## DECISION DELEGATED TO DEVELOPMENT MANAGER

**Application No:** H16-0912-18      **Applicant:** Solarcap Ltd  
**Proposal:** Proposed conversion into 2 apartments  
**Location:** 5 Bond Street Court Spalding  
**Terminal Date:** 9th November 2018

South-West Elevation

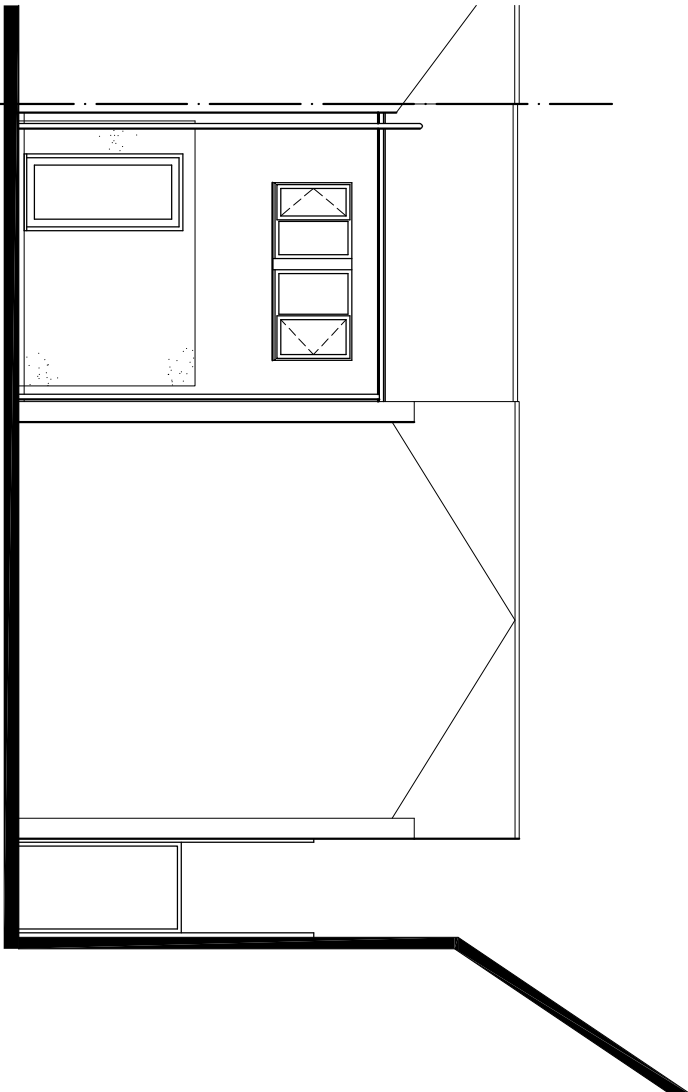
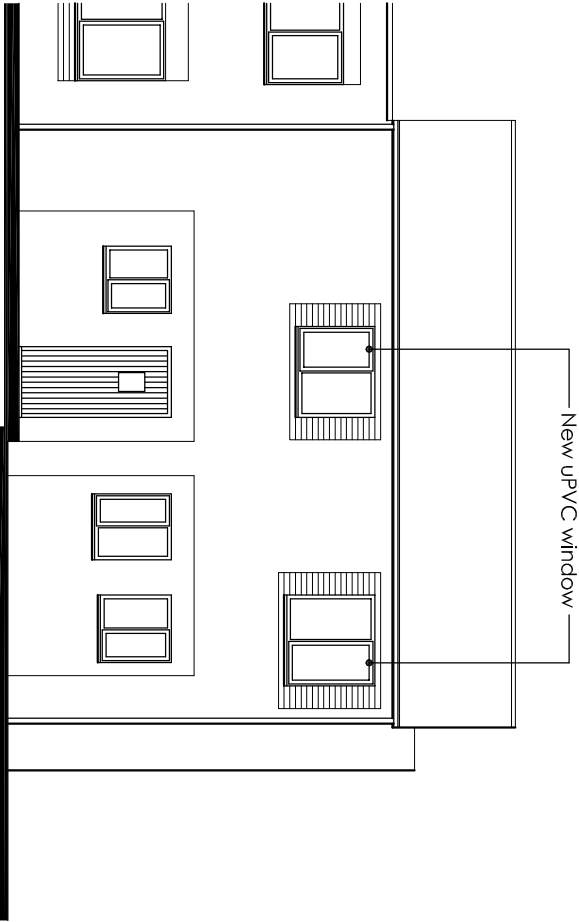
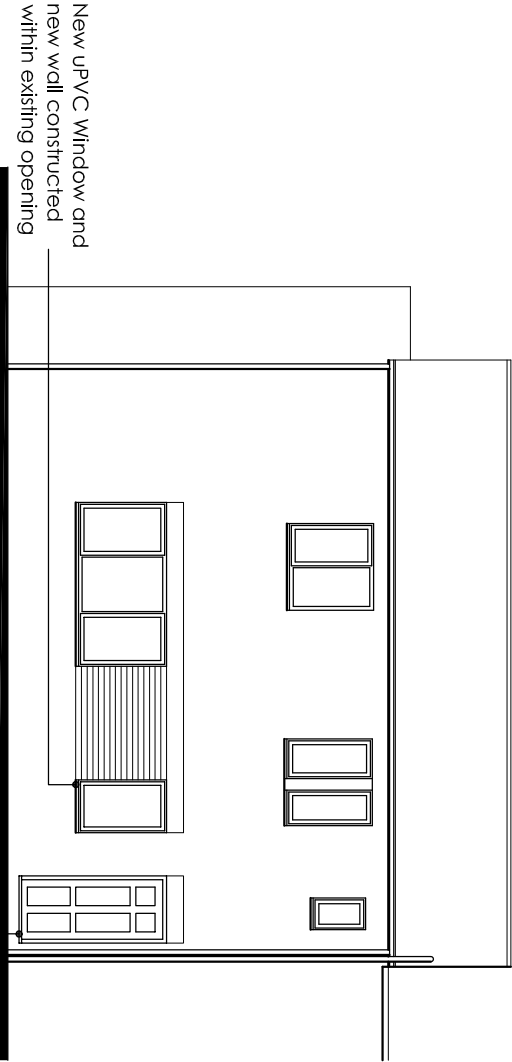
The only external alterations would be the opening up of a former window opening at ground floor on the south-western elevation and the creation of two new window openings at first floor on the north-eastern elevation.

The proposed external alterations are considered to be acceptable. The site is outside of Spalding Conservation Area, is set back from the street and the alterations would only be minor.

Ground Floor Plan

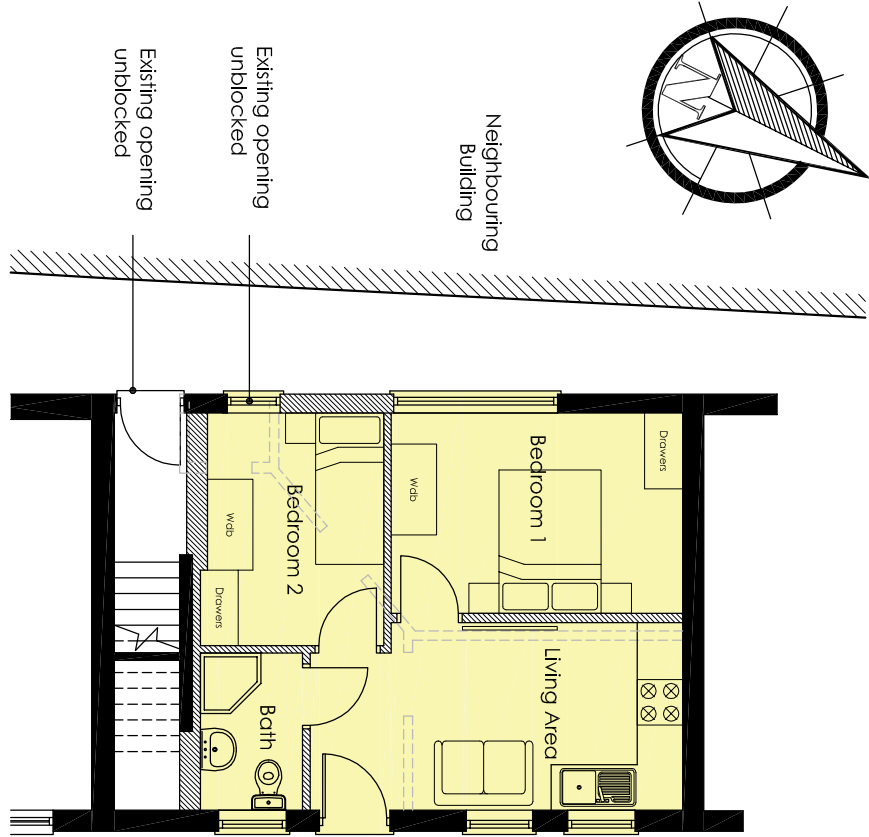
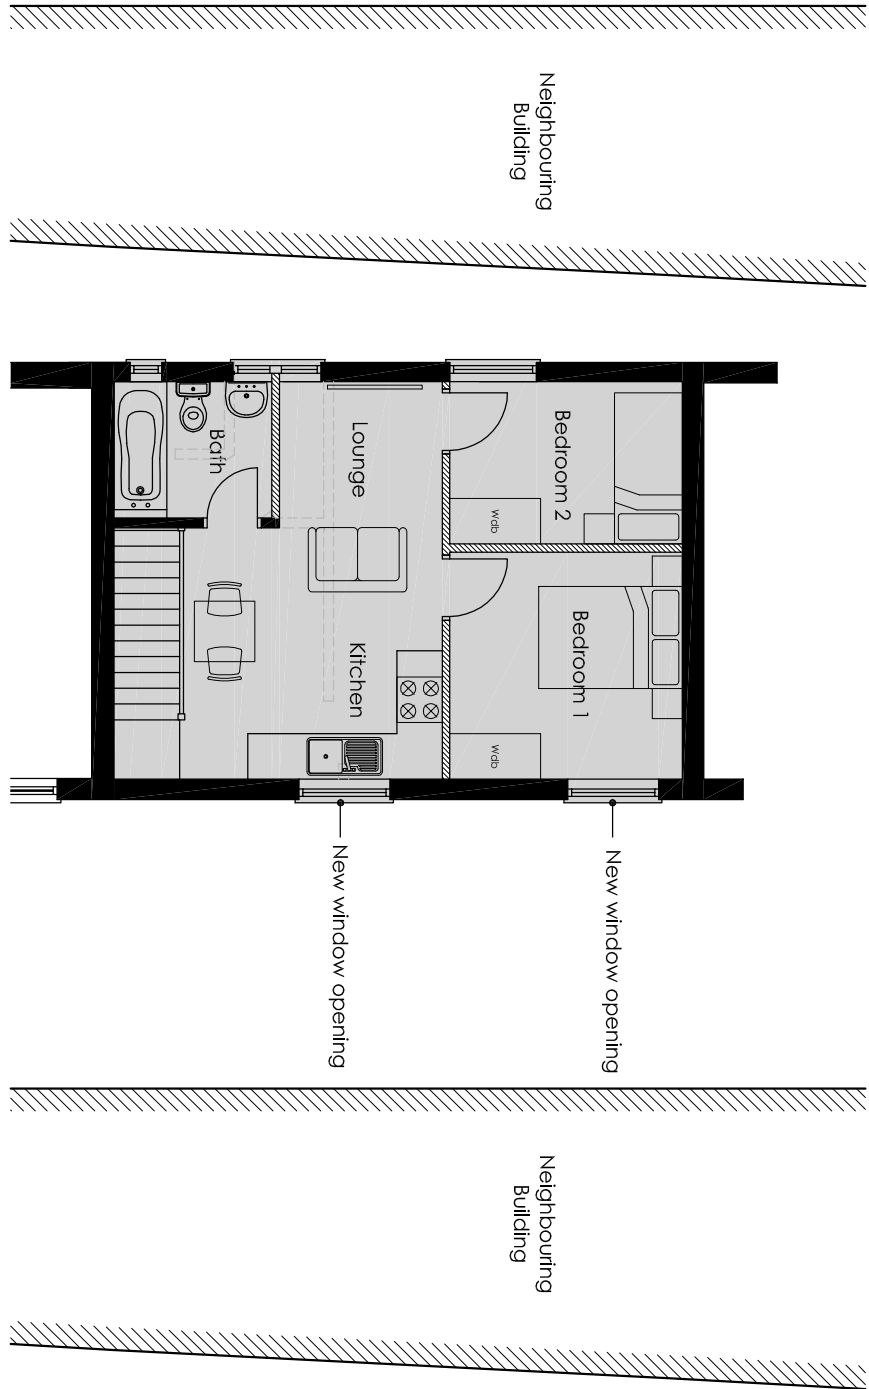
The ground floor apartment would comprise of one double bedroom, a bathroom and an open plan living area, which includes the kitchen and the lounge. The first floor apartment would have a double bedroom and a single bedroom with bathroom and open plan living area. The apartments would be accessed by a gated alley off Winsover Road. No parking or vehicular access is proposed.

There are no South Holland specific space standards which relate to this type of conversion and the Nationally Described Space Standards do not form part of an adopted Local Plan and so are for guidance only. A judgement must however be made as to whether an acceptable level of space would be provided. It was originally proposed that the ground floor flat be 2 bedroom (one double and one single). However, given that the flat was intended to be occupied by 3 persons, it was considered that, overall, this would have offered future occupiers an unacceptable standard of amenity in terms of the space that would be created. The space dedicated to the kitchen and living area was limited and no dining area was available. Amended plans have been submitted which show the ground floor flat as a 1 bedroom unit instead, with a much more spacious cooking, eating and living area. This is now considered to be acceptable. In terms of the first floor flat, the proposed cooking, eating and living area was better than the ground floor flat, but it would still have been cramped for 3 persons. The plans have therefore been amended with the layout being altered so as to accommodate a larger living area. This is considered to be an acceptable improvement.
